**Re: Engineers Certification – Catamount @ 7 Bar North Subdivision
(for: Trail and Landscaping Area) (A-10/D007B1)
Submitted for Release of Remaining Financial Guaranty
Engineering Certification: Letter dated December 11, 2000**

RE: Grading and Drainage Certification for Catamount at Seven Bar North Subdivision (A13/D7B1) Submitted for Release of Financial Guarantees, Engineer's Certification Stamp Dated 7/7/00.

CATAMOUNT AT SEVEN BAR NORTH
GRADING PLAN

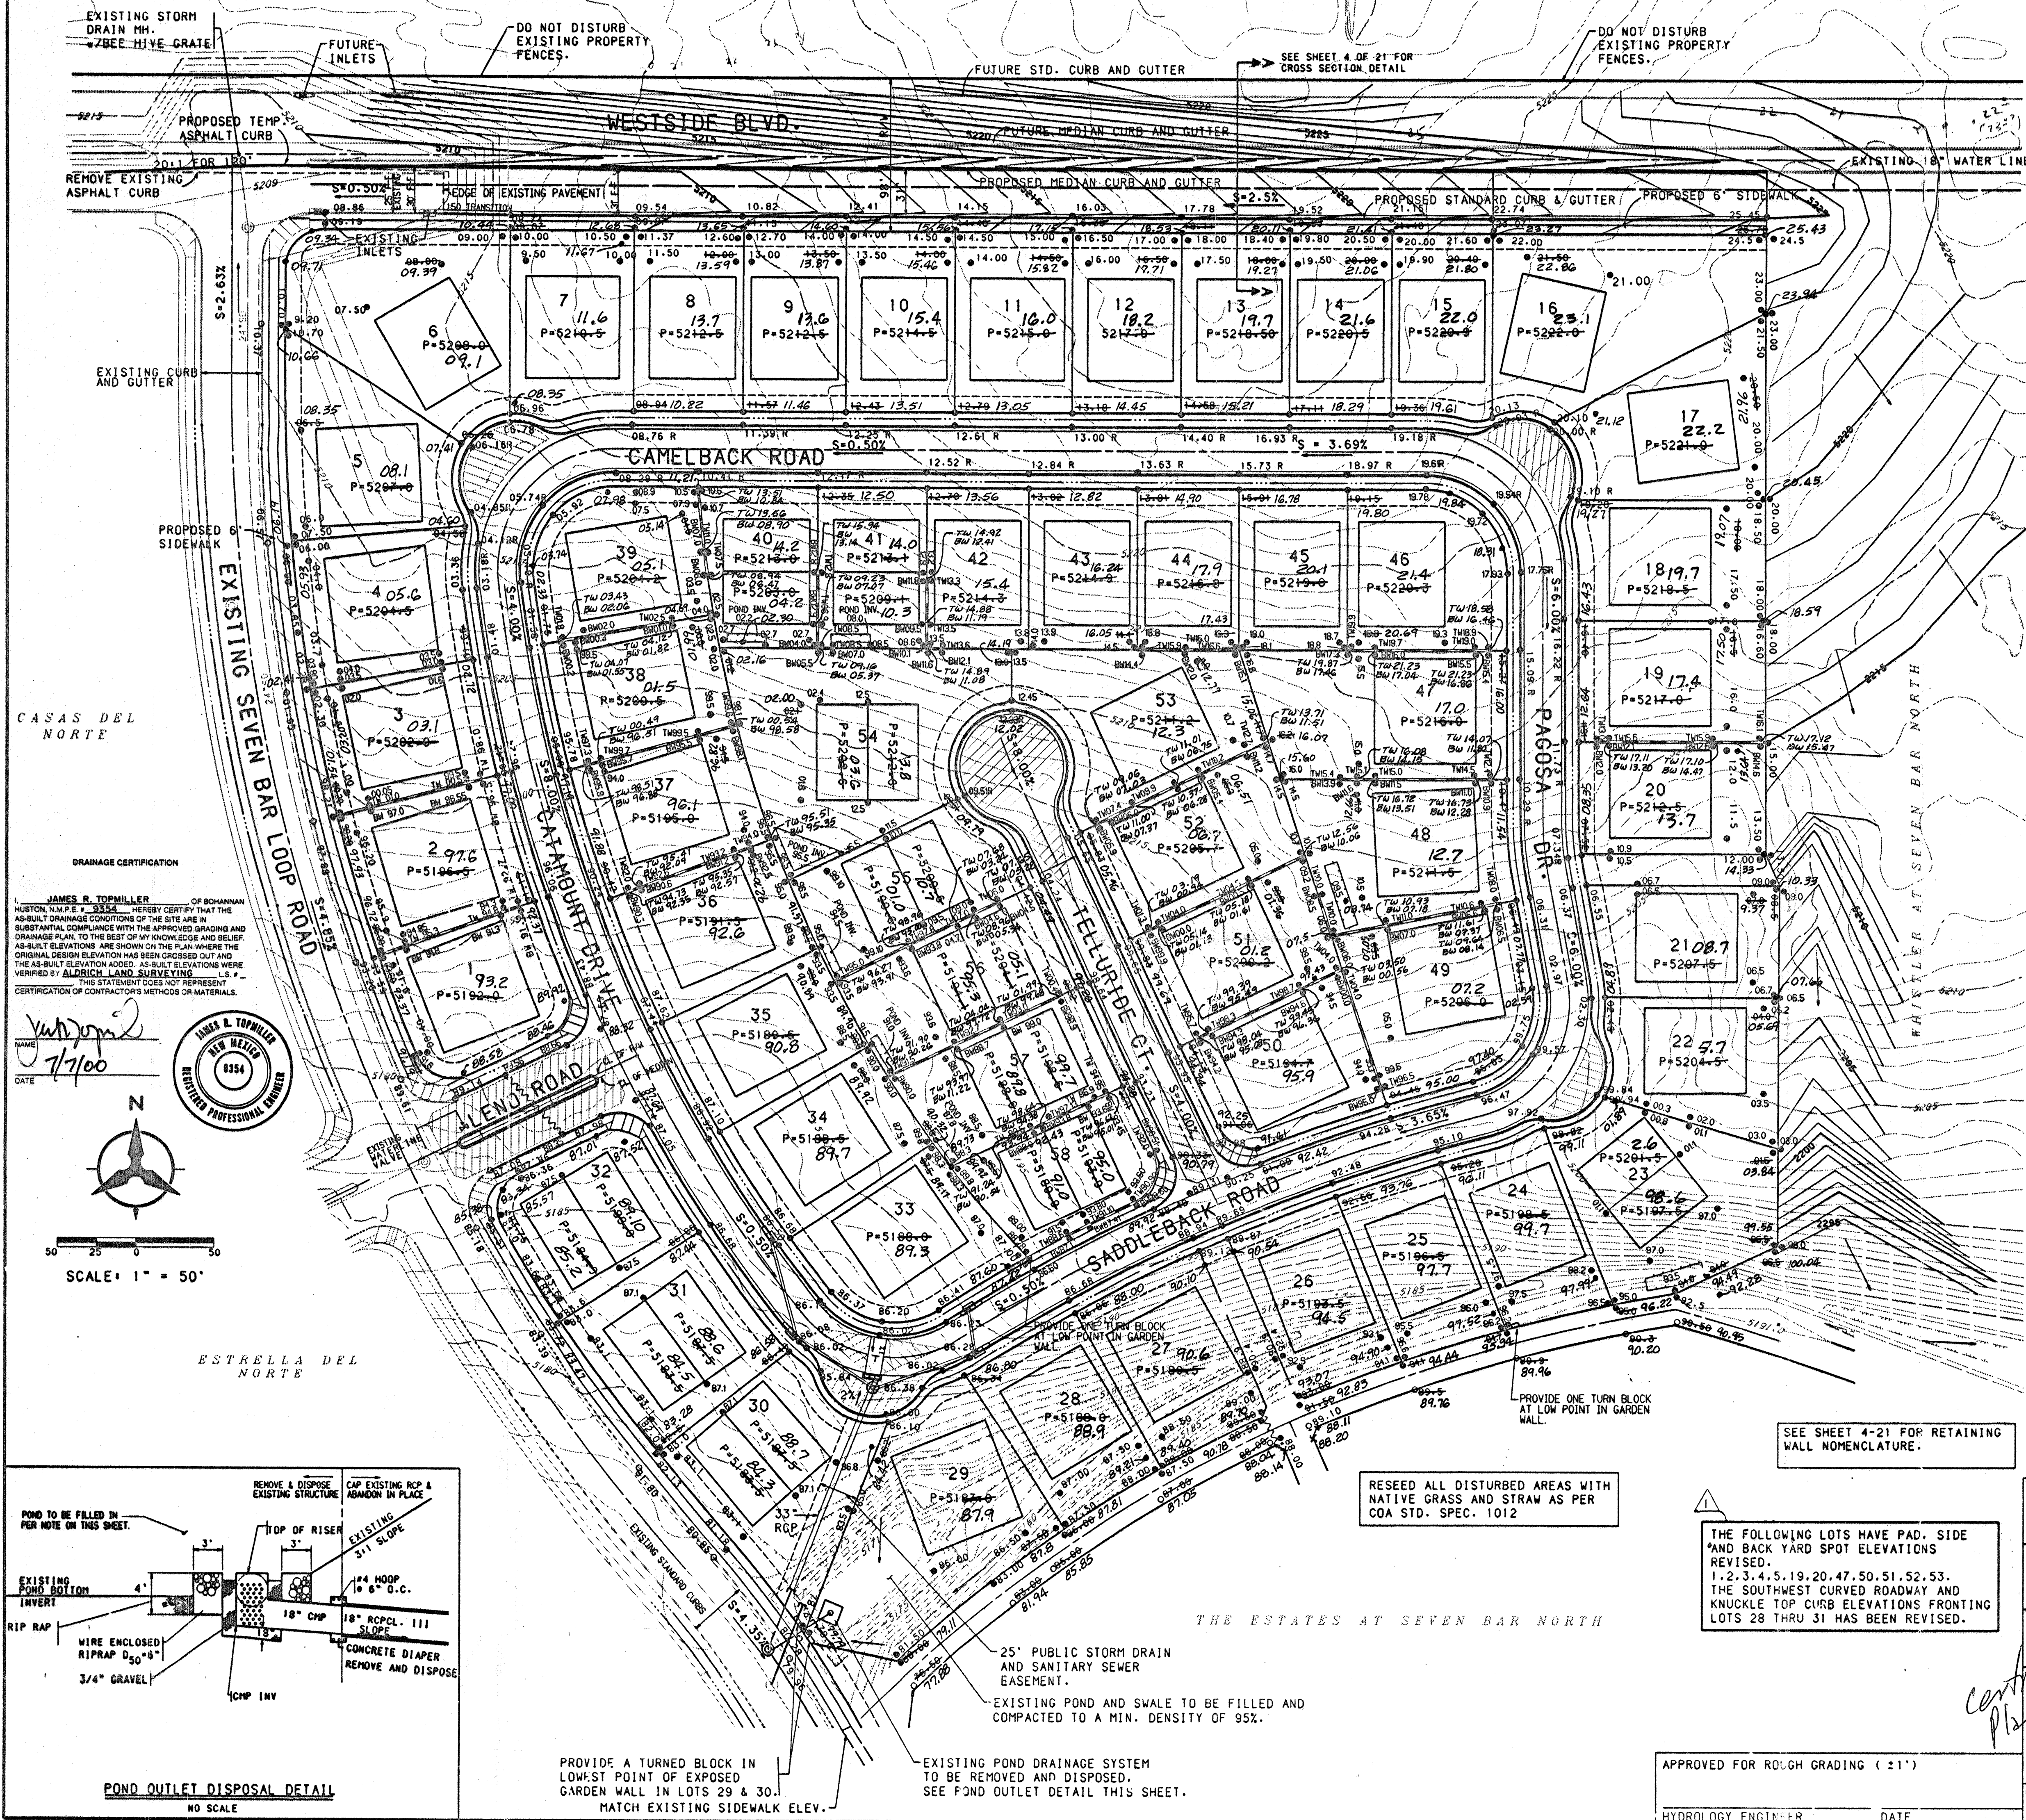
A cashier's check in the amount of \$15,000.00 for the purpose of providing a financial guaranty for the "unresolved drainage issues" has been required. Prior to release of this remaining financial guaranty, you must certify that the trail and landscape area has been completed such that this area drains out to the public right-of-way without impacting any private properties. This certification must also address the issue of the 18" of fill material against the existing walls.
